Appeal Decision

Appeal Ref: APP/R4408/W/20/3251598

Land at 21 to 24 Wentworth View, Wombwell, Barnsley S73 0LA

- The appeal is made under section 78 of the Town and Country Planning Act 1990 against a refusal to grant planning permission.
 - The appeal is made by Mr Paul Smith against the decision of Barnsley Metropolitan Borough Council.
 - The application Ref 2020/0012, dated 4 January 2020, was refused by notice dated 10 March 2020.
 - The development proposed is extension to existing building to create a third storey to allow the formation of 2 no. additional flats and alterations to access and parking provision.
-

Block Plan and car parking Land at 21/24 Wentworth View Wombwell, Barnsley, S73 0LA	Scale 1:500 When plotted A4	Plan Ref Smith-P-BL3 Date 28/02/2020
---	-----------------------------------	--

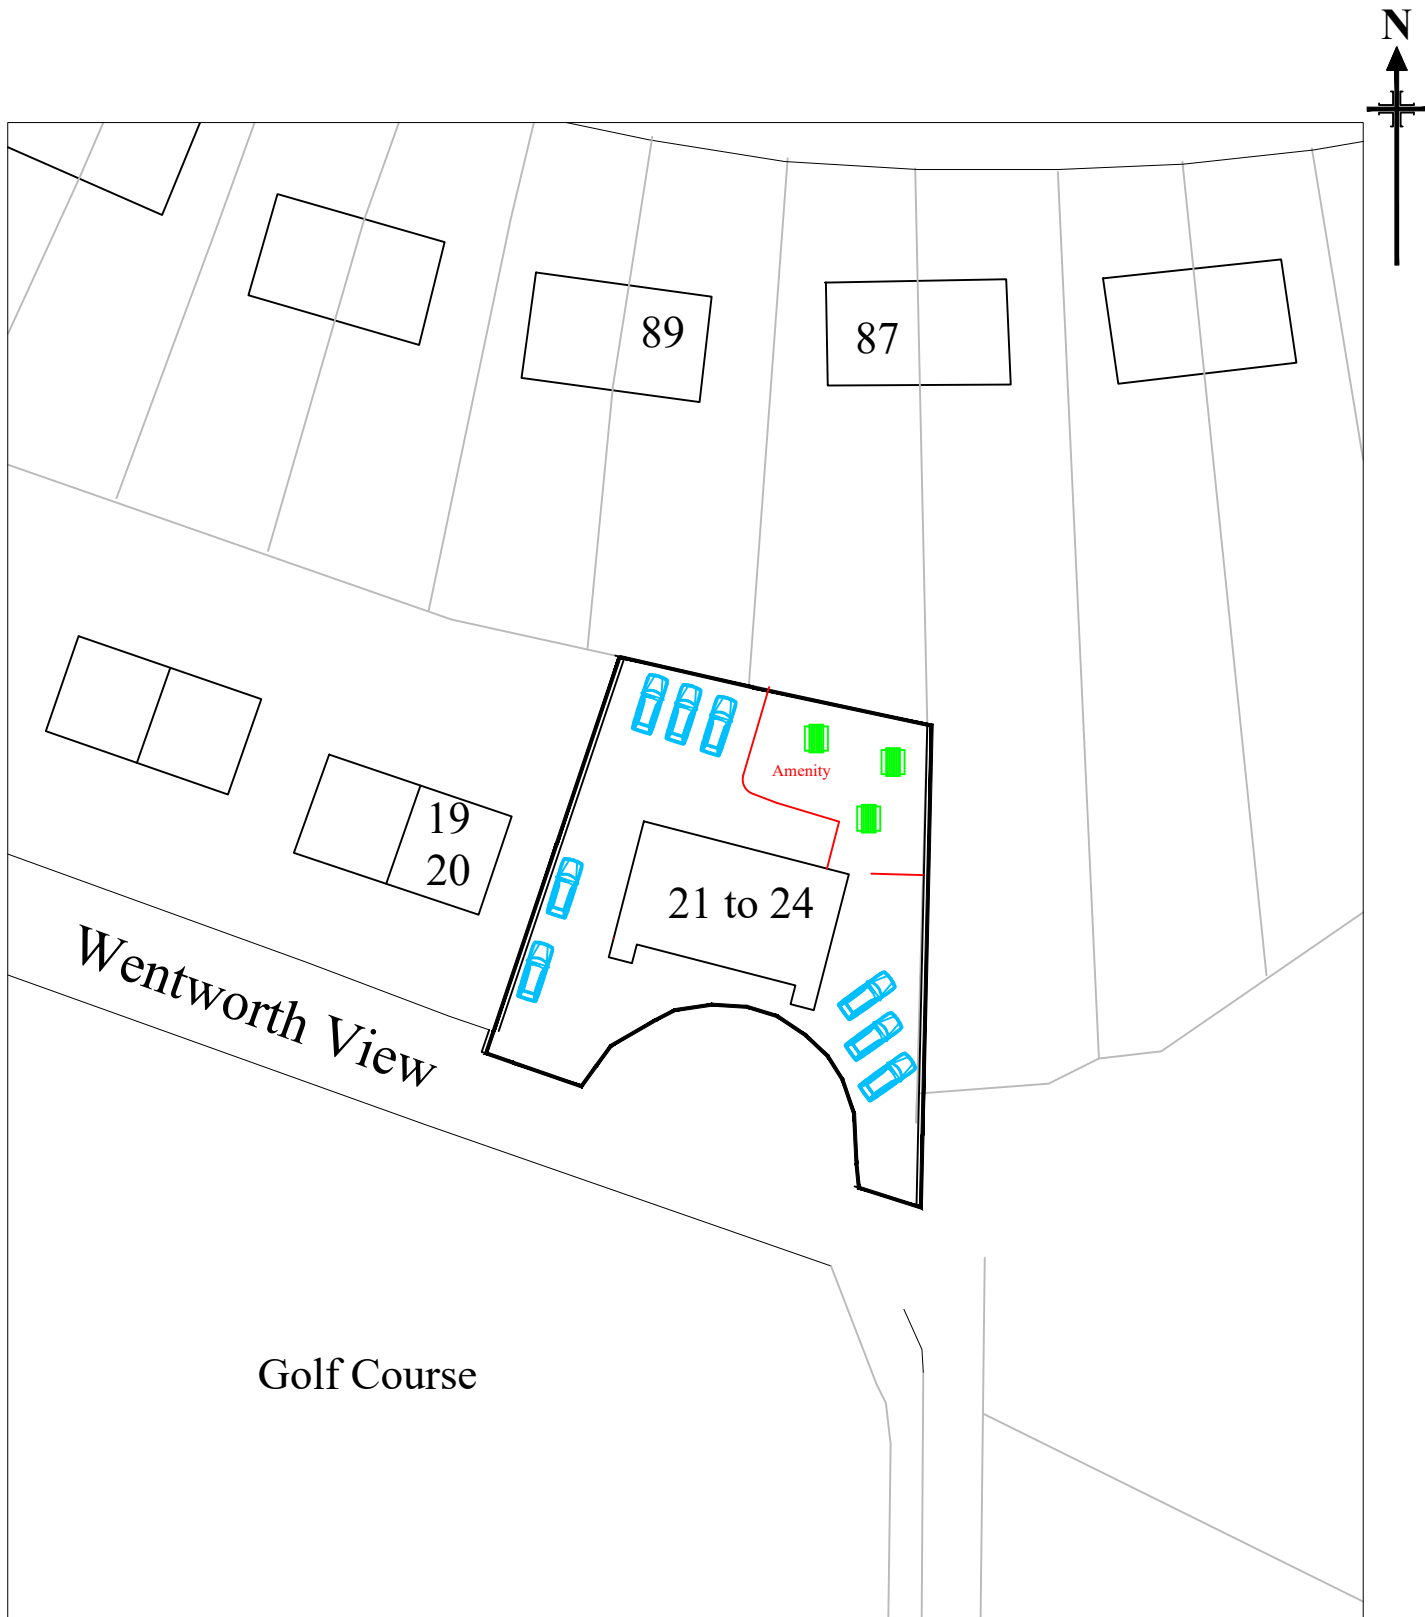
6. The amended block plan submitted by the appellant shows a number of off-street parking spaces, including in the rear garden and adjacent to the head of the cul-de-sac. However, I saw that the arrangement of the existing public highway and the space available for parking appeared to be more constrained than shown on the plans, including space for the manoeuvring of vehicles as well as the effect of planting and means of enclosure on access to vehicles and the opening of car doors. Restrictions of this nature may result in the projection of parked vehicles onto the carriageway or displacement of parking onto the turning head.

7. The site is in a particularly sensitive location next to a turning area at the head of a cul-de-sac. Any conflict between parked vehicles and the manoeuvring of utility and other vehicles could lead to awkward and convoluted vehicle movements detrimental to highway safety. This may also result in larger vehicles reversing along the full length of Wentworth View to depart the area. The access to the public footpath across the turning area and the potential for conflict between vehicles and pedestrians adds to my concerns on this matter.

8. The relationship between vehicles manoeuvring on the rear parking area and resident access to the amenity space should also be appropriately considered.

9. Whilst it may be possible to provide the required number of off-street parking spaces, details to enable a suitable assessment as to how this would relate to the movement of vehicles and pedestrians on the highway have not been provided, for example through the provision of a swept path analysis. Due to the potential effect on public safety and taking a precautionary approach, I do not consider that it would be appropriate to require these details by condition.
